# PRELIMINARY & FINAL DRAINAGE PLAN

## CARRIAGE MEADOWS SOUTH AT LORSON RANCH FILING NO. 2

**DECEMBER, 2018  
REV. JUNE 18, 2019**

PUDSP-19-005

### Routed Hydrograph Results

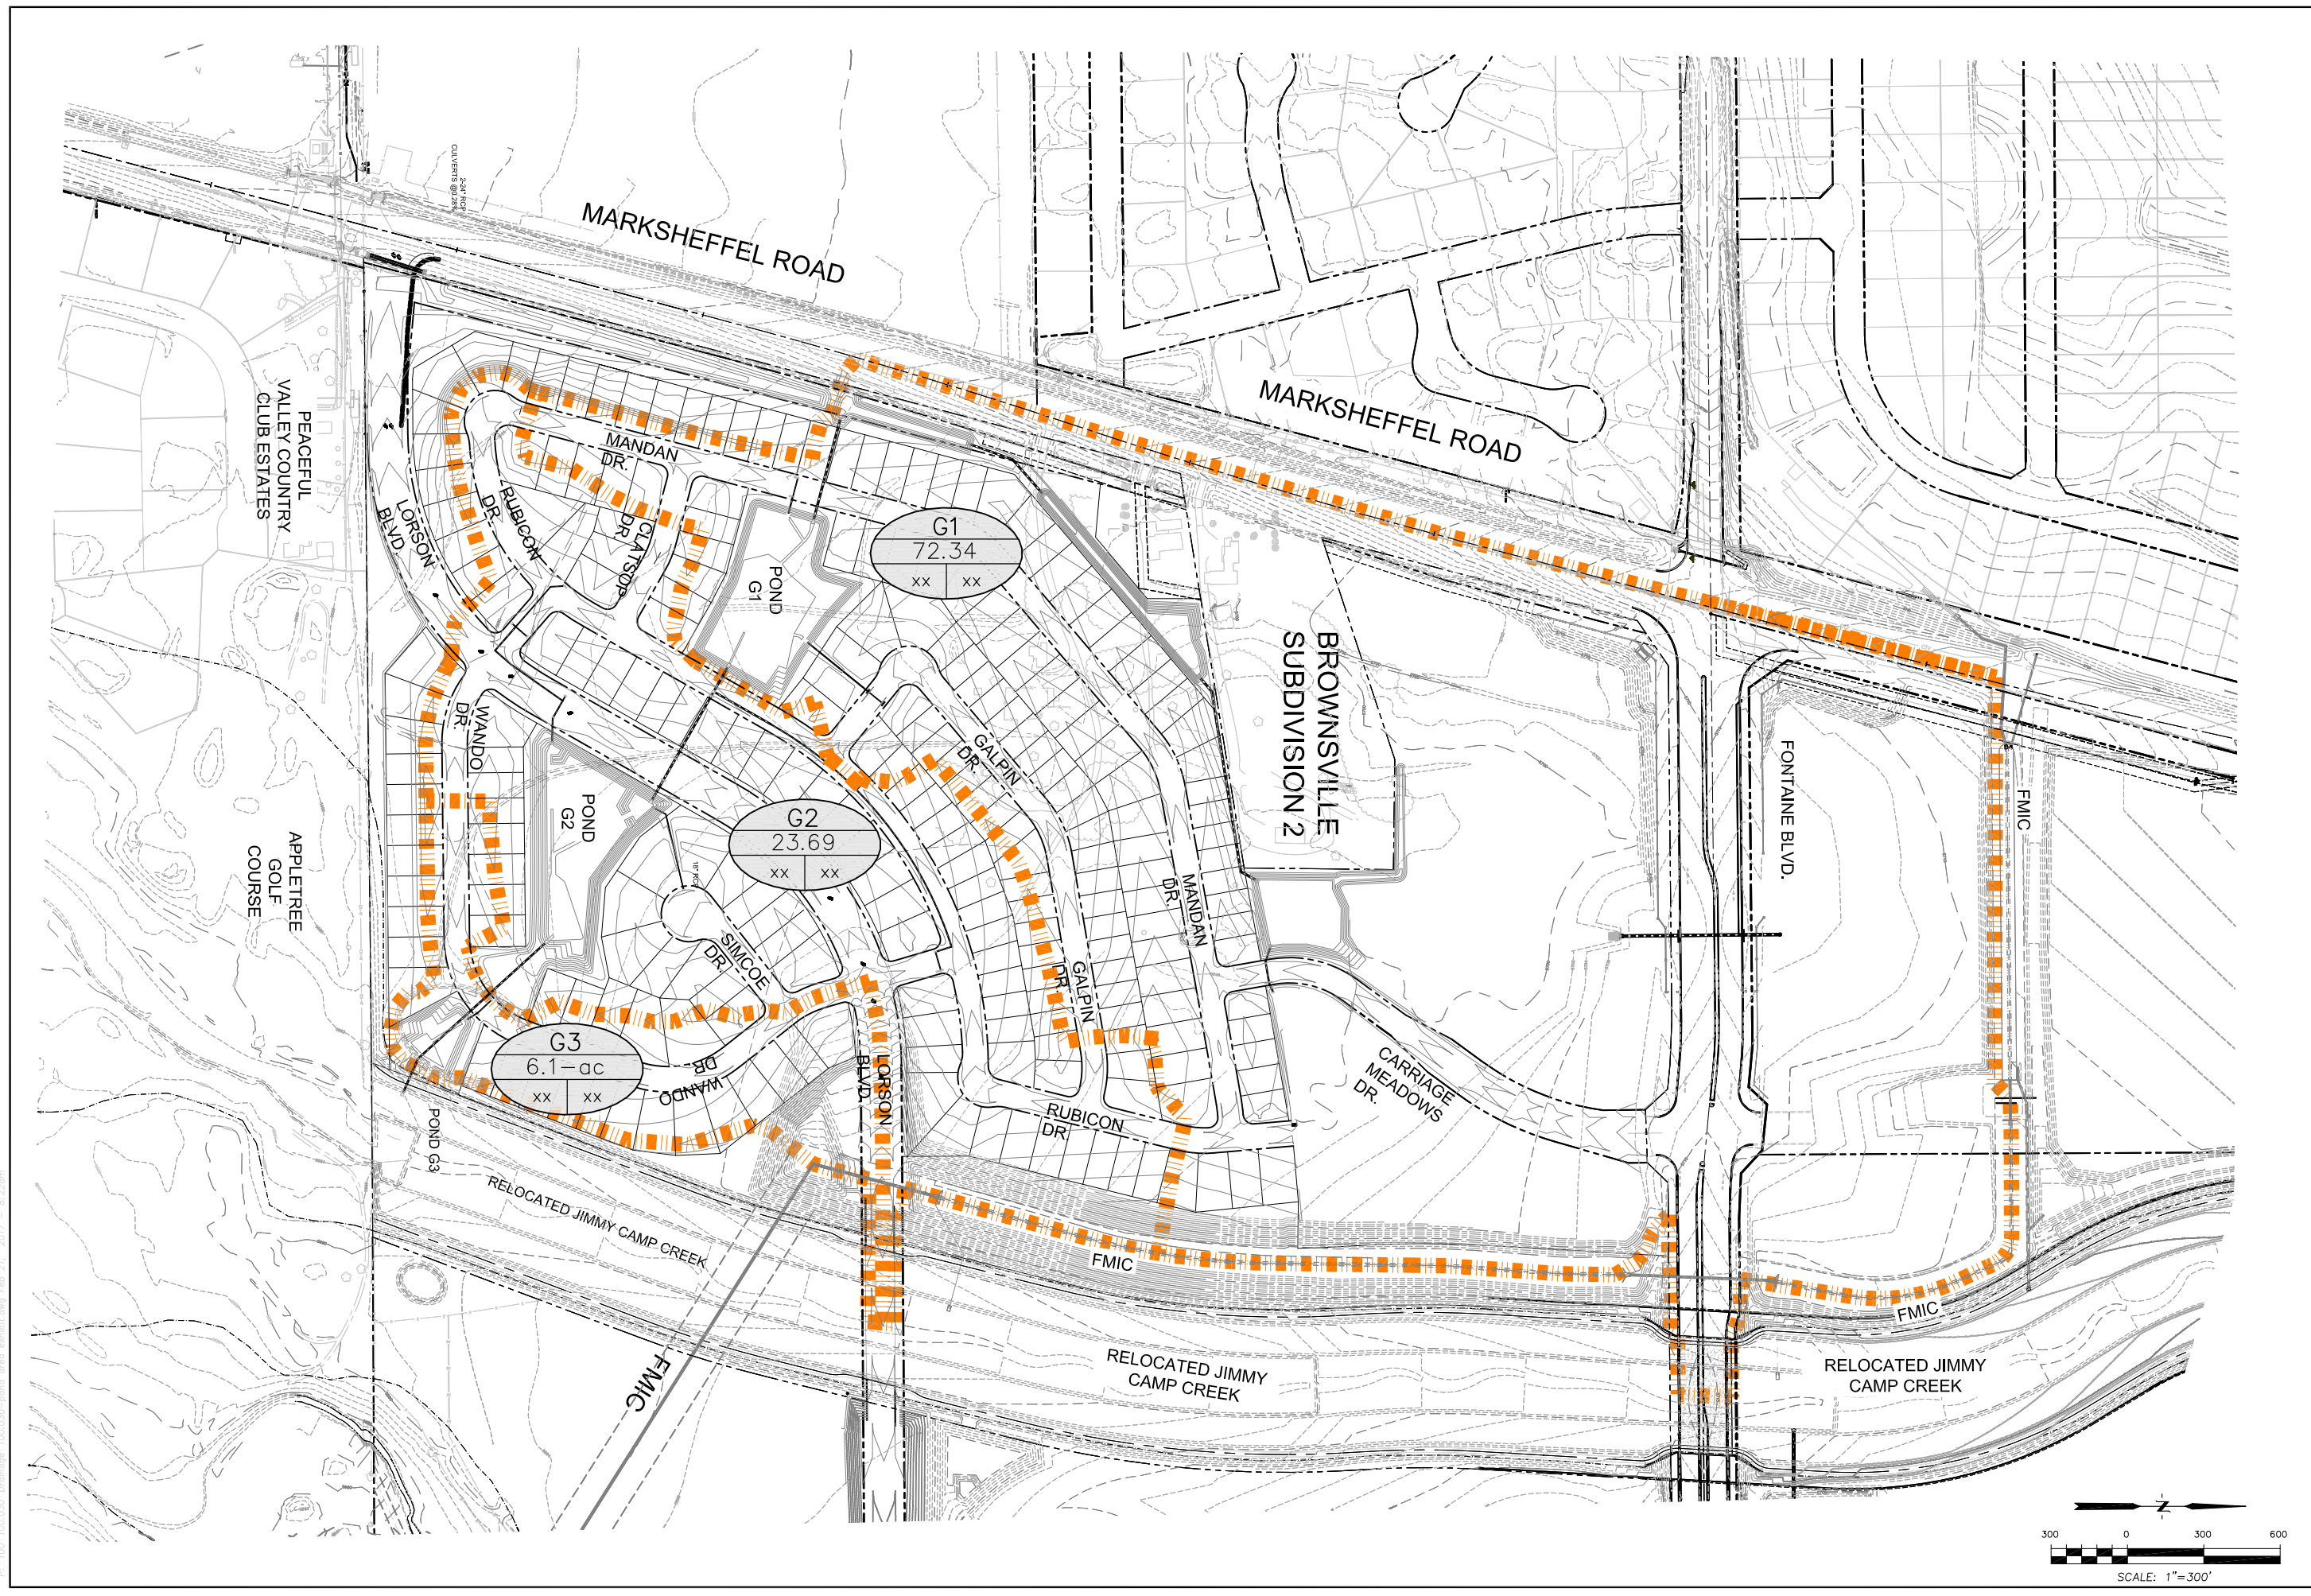
Can this be adjusted? Is the outlet structure designed to be updated with each additional development?

Author: RSchindler Subject: Sticky Note Date: 10/14/2019 8:52:11 AM  
 This would be hard to adjust since the outlet structure designed/built for full buildout.

**MAP POCKET**

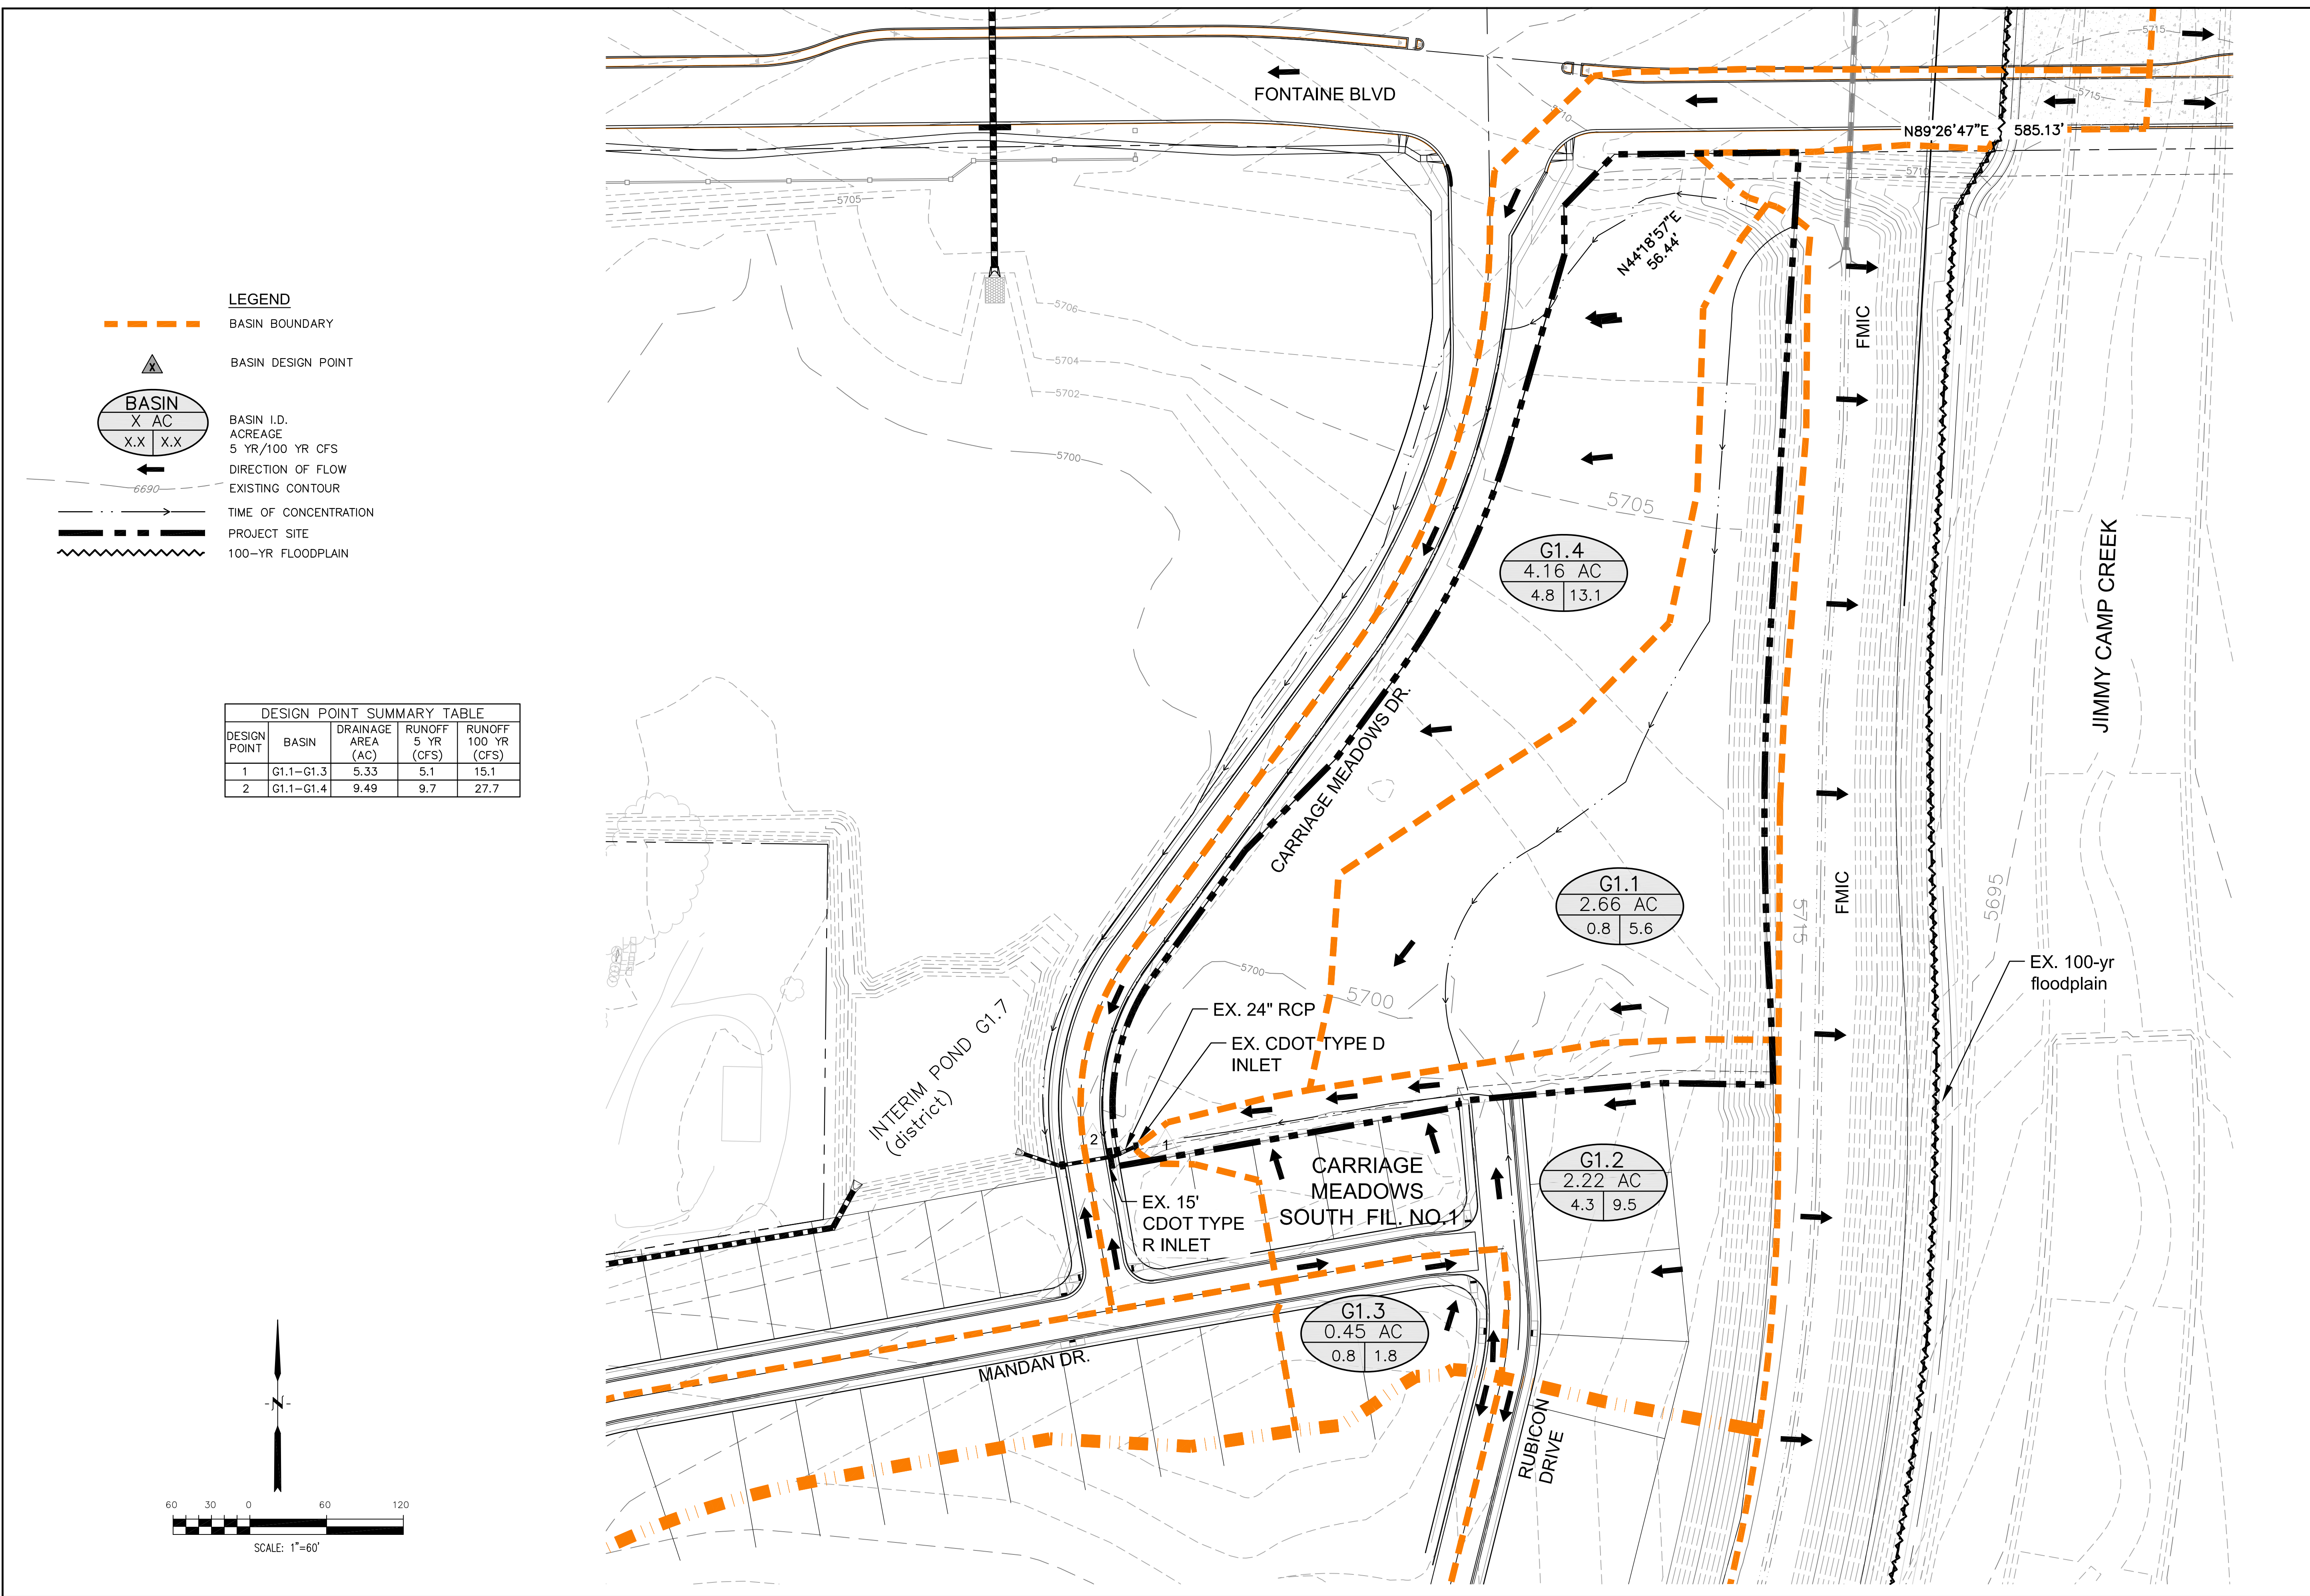
Label that the existing FSD facility is downstream from this pipe.

Author: RSchindler Subject: Sticky Note Date: 10/14/2019 8:54:23 AM  
Label added
